CITY OF ALBUQUERQUE

**RE: Central Mercado
201 San Pedro SE
Grading and Drainage Plan
Engineer's Stamp Date: 06/11/21
Hydrology File: K18D111**

Based upon the information provided in your submittal received 06/14/2021, the Grading and Drainage Plan **is not** approved for Building Permit. The following comments need to be addressed for approval of the above referenced project:

SHEET NO:
C-2

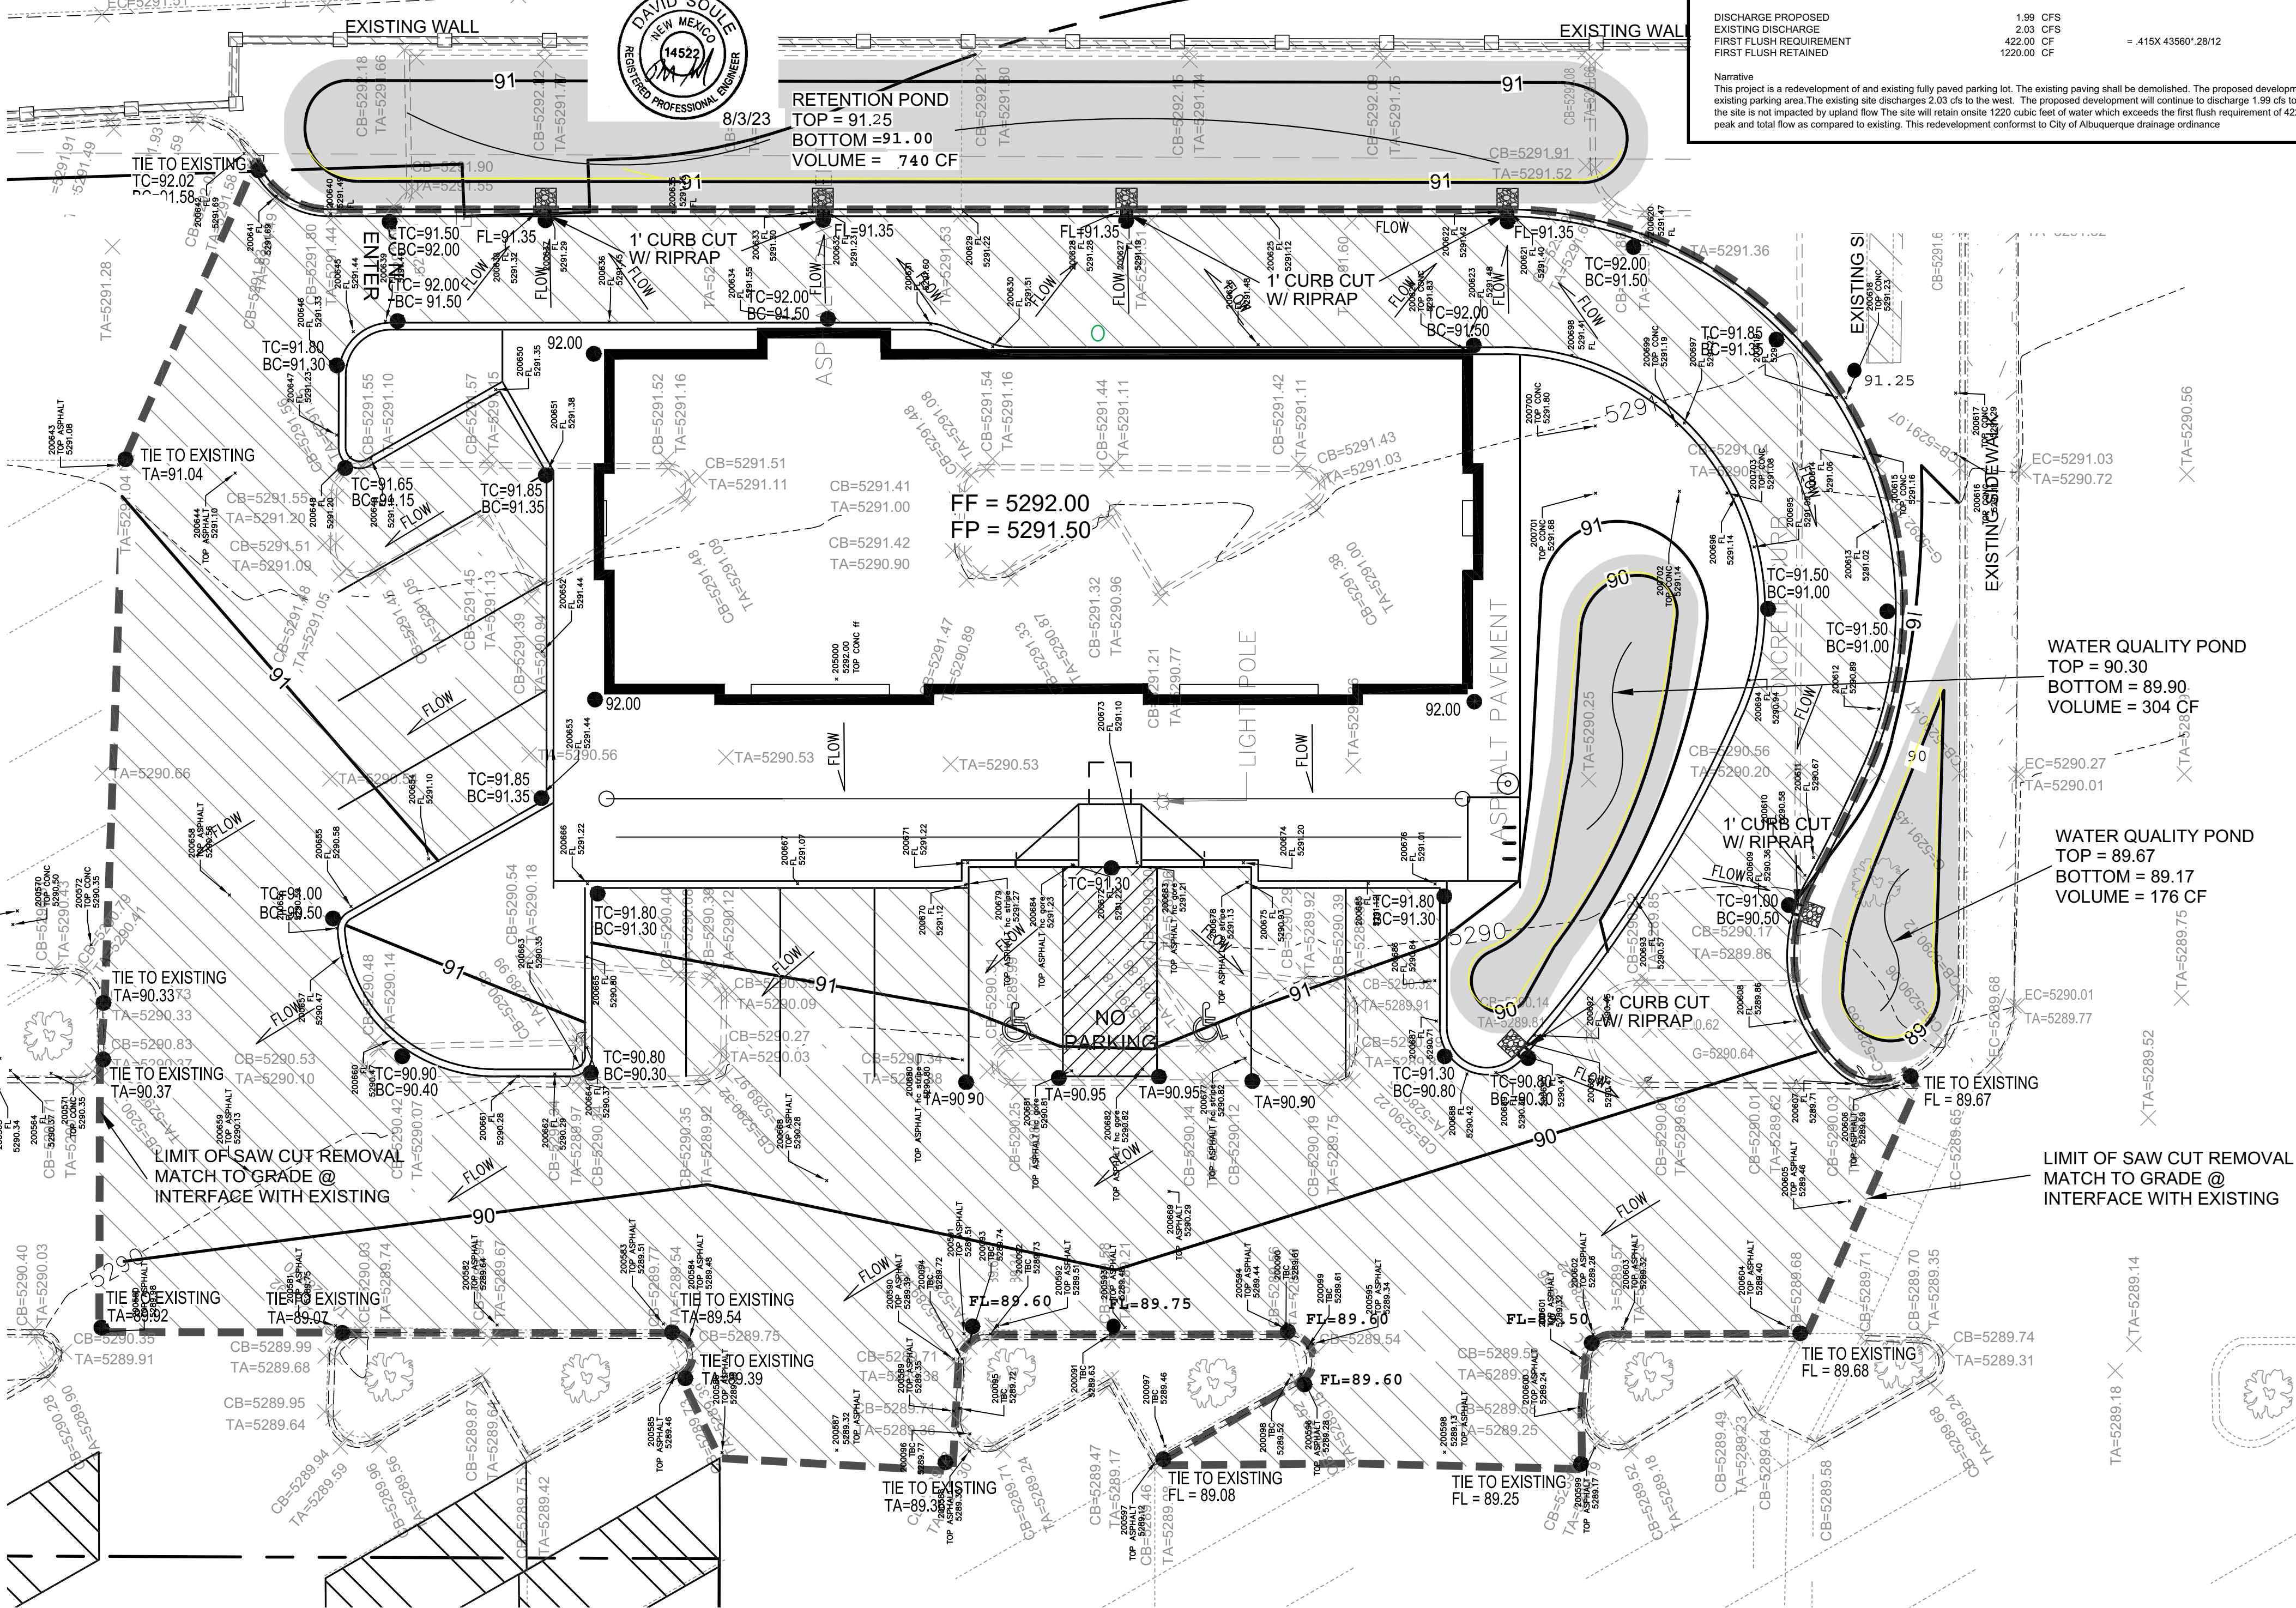
1. There will need to be a replat of the property. There is a property line going through the proposed building. A Building Permit will not be issued for a building with a property line through it. The plat will have to be submitted to the DRB (Development Review Board) for approval.

2. The drawing shows and labels an existing retaining wall. However a street view taken February 2021 does not show this existing wall. It appears that this does not exist. With this and the lot line issues, I question the existing survey information. Please provide a more accurate survey.
